Our Ref: J090110

**Certifying Authority Services
157 Redfern Street, Redfern**

BCA Compliance Report

Project: 157 Redfern Street, Redfern

PATN	TITLE	DATE	SCALE	DWG No.
JABEN0208	Redfern Retail & NVA Development's CAD/08 & Level 1 (Ground) Floor Plan (Development DA)	Feb 2009	1:100	DA100 C

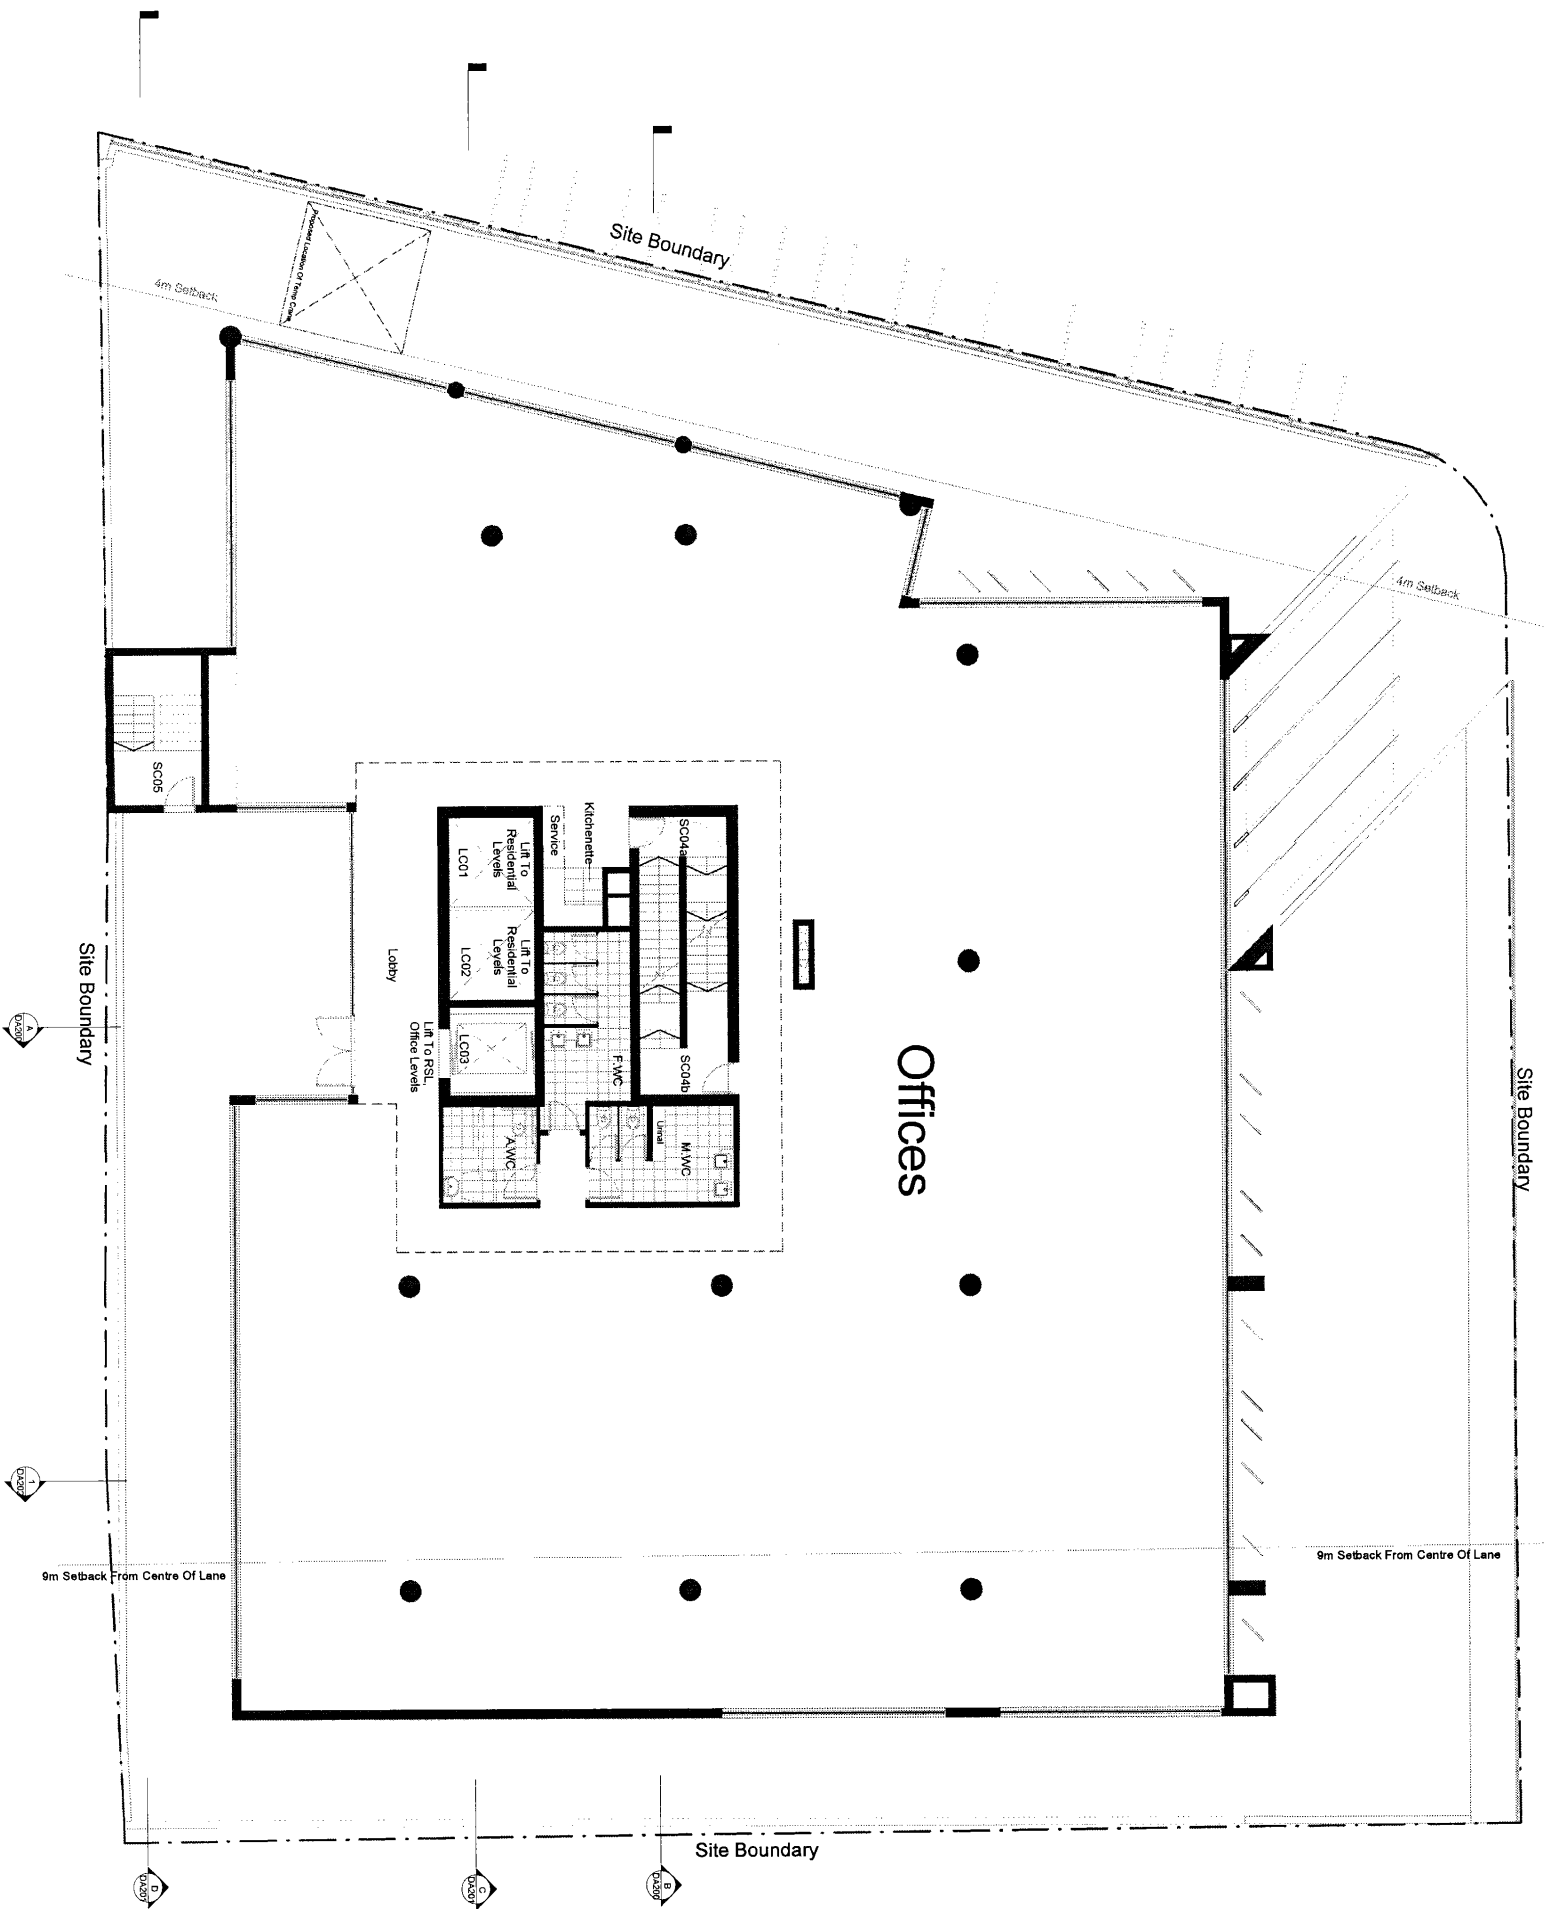
- (I) With regards to the requirement for a zone smoke control system to commercial floors of the building it is advised compliance may not be possible with AS/NZS1668.1 due to openings etc within external walls on the ground floor not allowing required pressure differentials. In this regard an alternative solution may be applicable as determined by a Fire Engineer.
- (II) The spiral stairs to the top most storey are to comply with BCA volume 2 provisions
- (III) Under NSW Place of Public Entertainment provisions the club level is to be fire separated from the ground floor level with construction achieving not less than 60/60/60
- (IV) Egress to the commercial floors is to be resolved in respect of tenancy configurations and if required subject to an alternate solution

D1.10	<u>Discharge from exits</u>	Egress over the lane is to be confirmed in respect of either being a public lane or has consented use for egress.
	Bollards or other suitable barriers are to be provided to ensure that exits must are not blocked by parked vehicles. Be located as far apart as practical. Required exit widths must be maintained between the discharge point of the exits and the roadway and the path connecting the exit to the road must have stairs and/or ramps connecting it.
